Tween Bridge Solar Farm

9.6 Statement of Common Ground with Lincolnshire Wildlife Trust

Document Reference: 9.~~5~~6

Figure 2: Non Breeding Bird Mitigation Plan – No Annotation

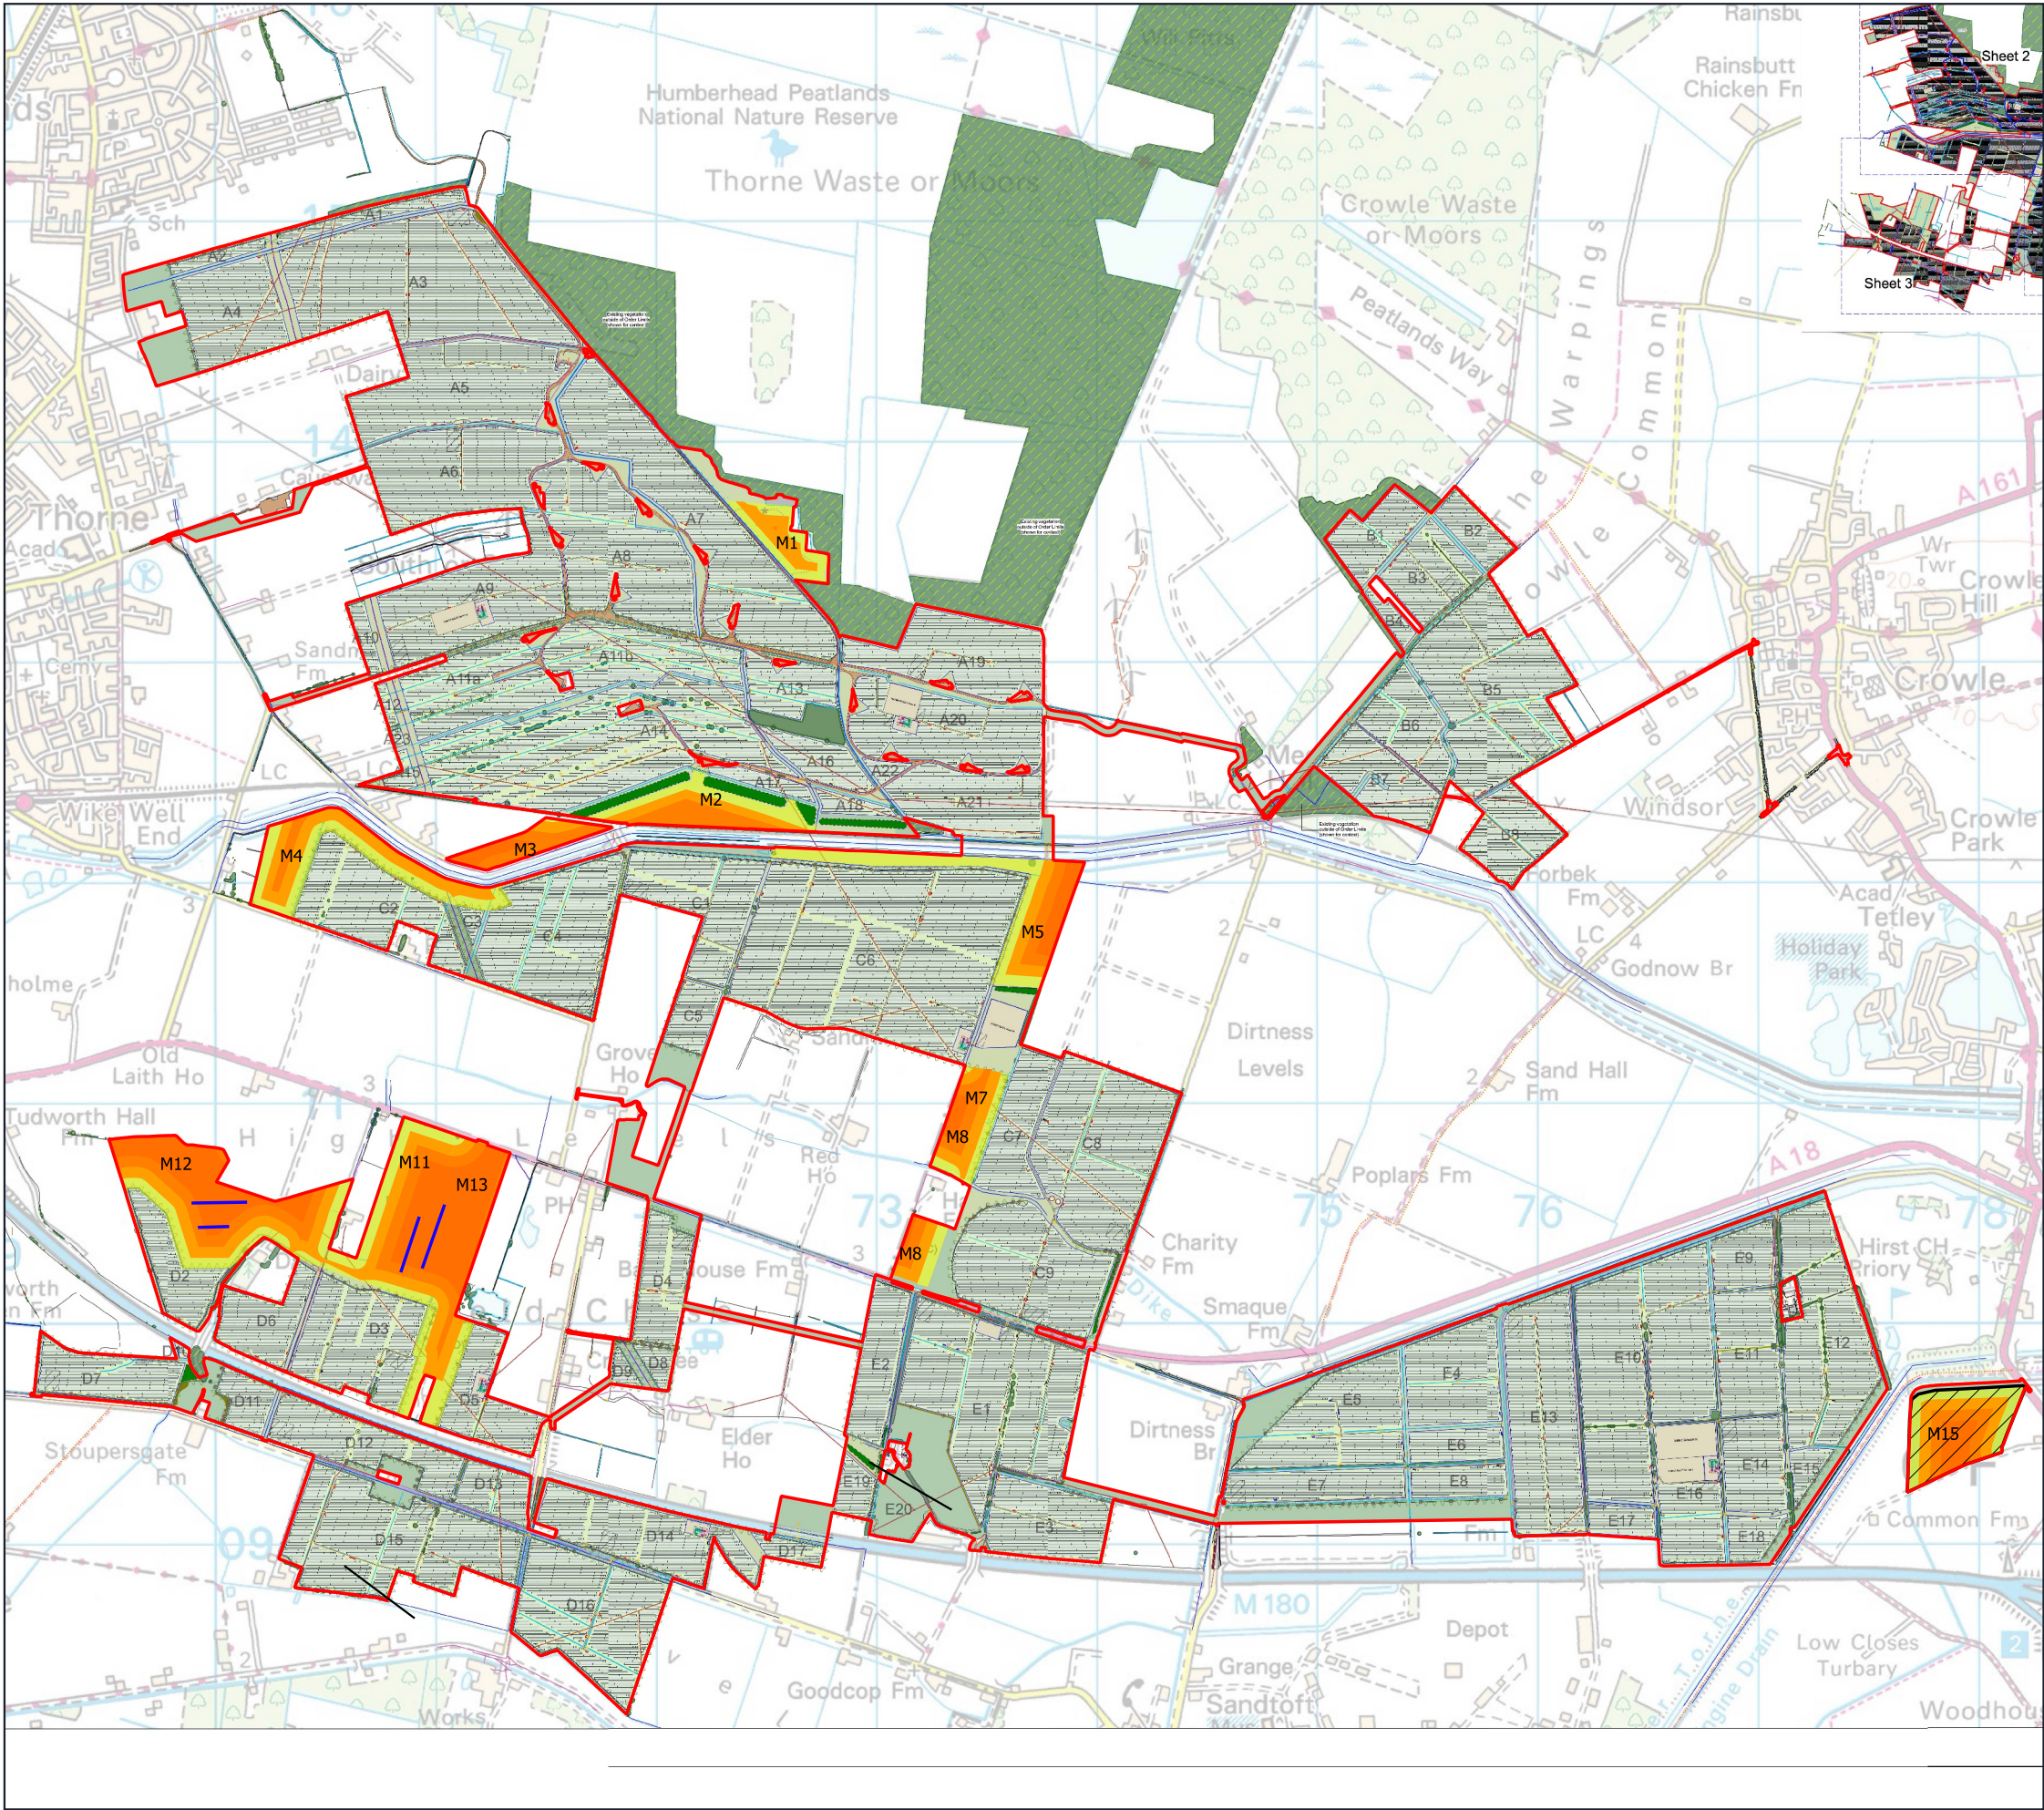
<u>not appear to account for this higher carrying capacity habitat.</u> The Trust has also undertaken a mapping review comparing the Year 1 and Year 2 survey results with the proposed mitigation parcels. This indicates that Area B supported comparable or higher peak counts of lapwing and pink-footed goose than a number of the selected mitigation parcels. The Trust therefore maintains its request for a clear explanation of the mitigation parcel selection criteria and the basis for not locating additional mitigation closer to Area B. <u>Updated Technical comments provided by LWT to The Applicant:</u> <u>Following a mapping review exercise, we have overlaid the bird count results for Lapwing and Pink Footed Geese presented in Document Reference 6.3.7.3 – Non-Breeding Bird Surveys Report (Year 1 and Year 2) against the Outline Non-Breeding Bird Mitigation Strategy (Document Reference 6.3.7.10) – where we have accounted for direct observations within field compartments, and also pooled counts from directly adjacent fields, or those considered directly proximal, as presented by</u>	Order Limits, or rely on any specific area. With regards to lapwing the first years of surveys in 2022–23 recorded high numbers in Area B. However, in the second years of surveys in 2023–24 significantly lower numbers were recorded in Area B (17 in total), with higher numbers recorded elsewhere within the Order Limits, demonstrating that lapwing do not rely on any one area in the Order Limits. The Applicant has designed the mitigation areas to reflect bird use where possible, whilst acknowledging that bird species move to areas of suitable habitat. As such, the mitigation design completed following consultation with Natural England has been designed to ensure the habitat requirement of bird species present, including those functionally linked to the SPA, are provided.

<u>the applicants maps within the survey boundary.</u> <u>In the main, we agree with the siting of several of the mitigation areas where they offer wider strategic benefits (M1), or deliver larger coherent blocks inline with the Lawton principles (M12, M11 & M13).</u> <u>However the rationale for some site selections appears to conflict with the narrative provided in the applicants response for discounting the need for strategic mitigation surrounding Area B.</u> <u>Area B records consistently high PFG counts across Years 1 and 2, averaging 1257, which would position it as having the second highest count in comparison to the several of the strategic mitigation areas presented, which reference PFG benefit or count numbers.</u> <u>Similarly Area B appears to provide a higher peak count for Lapwing than any mitigation area.</u> <u>In Table (6.3.7.10), the Column for 'Current Baseline' appears to be used as a measure of site suitability or justification, and we note the commentary as:</u> <u>- Mitigation Parcel M1 - 'Rough grassland set on the edge of the adjacent SPA, noted to be used by Lapwing (peak counts of 45 and 8 bird)...</u>	<u>Given the mobility of SPA bird species, and the location of the Order Limits being approximately 7.7 km from the Humber Estuary SPA, it is evident that SPA bird species are capable of travelling large distances and will utilise suitable habitat wherever it is available, rather than being depending on a single location.</u> <u>This is supported by the breeding and non-breeding bird survey data recorded by the Applicant, which demonstrates that bird species move around the Order Limits and wider area and do not only remain in one part of the Order Limits, or rely on a specific area.</u> <u>This is demonstrated by the results for lapwing. The first years of surveys in 2022-23 recorded high numbers of lapwing in Area B. However, in the second years of surveys in 2023-24 significantly lower numbers were recorded in Area B (17 in total), with higher numbers recorded elsewhere within the Order Limits, demonstrating that lapwing do not</u>

<u>Lapwing also recorded in adjacent field in larger numbers (112 and 32 birds)'</u> <u>- Mitigation Parcel M4 - 'Direct adjacent to plots used by lapwing'</u> <u>- Mitigation Parcel M5 - 'Peak count of 360 PFG, recorded within plot , and directly adjacent to other fields where PFG geese and lapwing were recorded'</u> <u>- Mitigation Parcel M7 - ' Forms one continuous parcel with parcel 8, albeit separated by a hedge and ditch. Had PFG recorded present'</u> <u>- Mitigation Parcels M11, M12, M13 - 'PFG record using fields in close proximity that comprise similar habitats'</u> <u>In review of our mapping cross reference exercise;</u> <u>Parcel M4 appears to have no direct counts of Lapwing within the field.</u> <u>Parcel M5 appears to have a Y1 peak count of 360 and Y2 count of 0 for PFG.</u> <u>Parcel M7 appears to have no direct counts of PFG within the field.</u> <u>Parcels M11, M12 and M13 - all appear to have 0 bird counts for Lapwing and PFG in Year 2, with peak counts of 465 Lapwing in M11 and 277 Lapwing in M12.</u> <u>In the context of Area B (and adjacent fields through a consistently applied approach).</u> <u>For Lapwing, Area B presents a peak count of 898 in Y1 and 23 in Y2. Which appears to align</u>	<u>rely on any one area in the Order Limits. Full results are detailed in 6.3.7.3 Environmental Statement Appendix 7.3 Non-Breeding Bird Survey Report (Year 1 and Year 2) [AS-015].</u> <u>The Applicant has designed the mitigation areas to reflect bird use where possible, whilst acknowledging that bird species move to areas of suitable habitat. As such, the mitigation design completed following consultation with Natural England has been designed to ensure the habitat requirement of bird species present, including those functionally linked to the SPA, are provided.</u> <u>The Applicant confirms that all mitigation measures, including the location of the mitigation areas, have been agreed with Natural England, as demonstrated by their Statement of Common Ground [Document Reference 9.9 Revision 5] ~~REP5-055~~, which states that this topic is Agreed.</u>

<u>and exceed the rationale presented for M1 and M4.</u> <u>For Pink Footed Geese, Area B presents a Y1 count of 803 and Y2 count of 1711, averaging 1257 across the survey period. This appears to align and exceed the justification provided in the identification of M5, M7, and M11, M12 & M13 as a combined block.</u> <u>Given this disparity, can the applicant provide a detailed explanation and breakdown of the mitigation site selection criteria and decision making process?</u> <u>From The Trusts perspective, the evidence indicates sub-optimal mitigation site positioning on the basis of Year 1 and Year 2 feature distribution.</u> <u>Whilst an insufficient justification has been provided for discounting the inclusion of targeted mitigation surrounding field block B, where Table 6.3.7.10 provides conflicting information for the Applicants site selection, indicating suboptimal positioning based on their own survey evidence. We do however recognise the updated comments and positions of key regulatory partners and need to balance interests. On this basis we will update our position to Agreed, noting the wider benefits of</u>	<u>The Applicant notes LWT's updated position and confirmation that this matter is now agreed, recognising the wider benefits of the mitigation layout and connectivity across the site. This matter has therefore been moved to Agreed in line with their position.</u>

<u>the mitigation plan layout and additionality provided by connectivity within the wider site.</u>		
		~~VII.~~ We note and welcome the identification of need for a significant skylark mitigation strategy and provisions proposed with oLEMP to replace lost nesting opportunities with compensatory land allocation.	~~VII.~~ The Applicant agrees that the Outline Landscape Ecological Management Plan [Document Reference 7.6 Revision 2] REP4-055 provides provisions to replace lost nesting opportunities and compensatory land allocation with regards to skylarks.	<u>Agreed</u>
		~~VIII. However, The Trust also notes with concern and reservation the distribution of the proposed bird mitigation parcels, and lack of proximity to Area B (Crowle). With reference to the bird survey results and species distribution it is apparent that a number of other species are aggregating in or near to the Crowle warplings. As recognised, warplings form a transitional habitat on the periphery of peatlands, and commonly create damp arable or wet grasslands supporting high densities of soil invertebrates. The proposed mitigation sites do not appear to account for this higher carrying capacity habitat.~~	~~VIII. As detailed above, the bird surveys undertaken by the Applicant demonstrate that bird species move around the Order Limits and wider area and do not rely or remain in one part of the Order Limits as detailed with ES Volume 2 ES Chapter 7 Ecology and Nature Conservation [AS-012 REP5-012]. Therefore, the Applicant has designed the mitigation areas to reflect bird use where possible, whilst acknowledging that bird species move to areas of suitable habitat. The Scheme's mitigation strategy can be seen in ES Figure 6.4 Landscape and Visual Mitigation~~
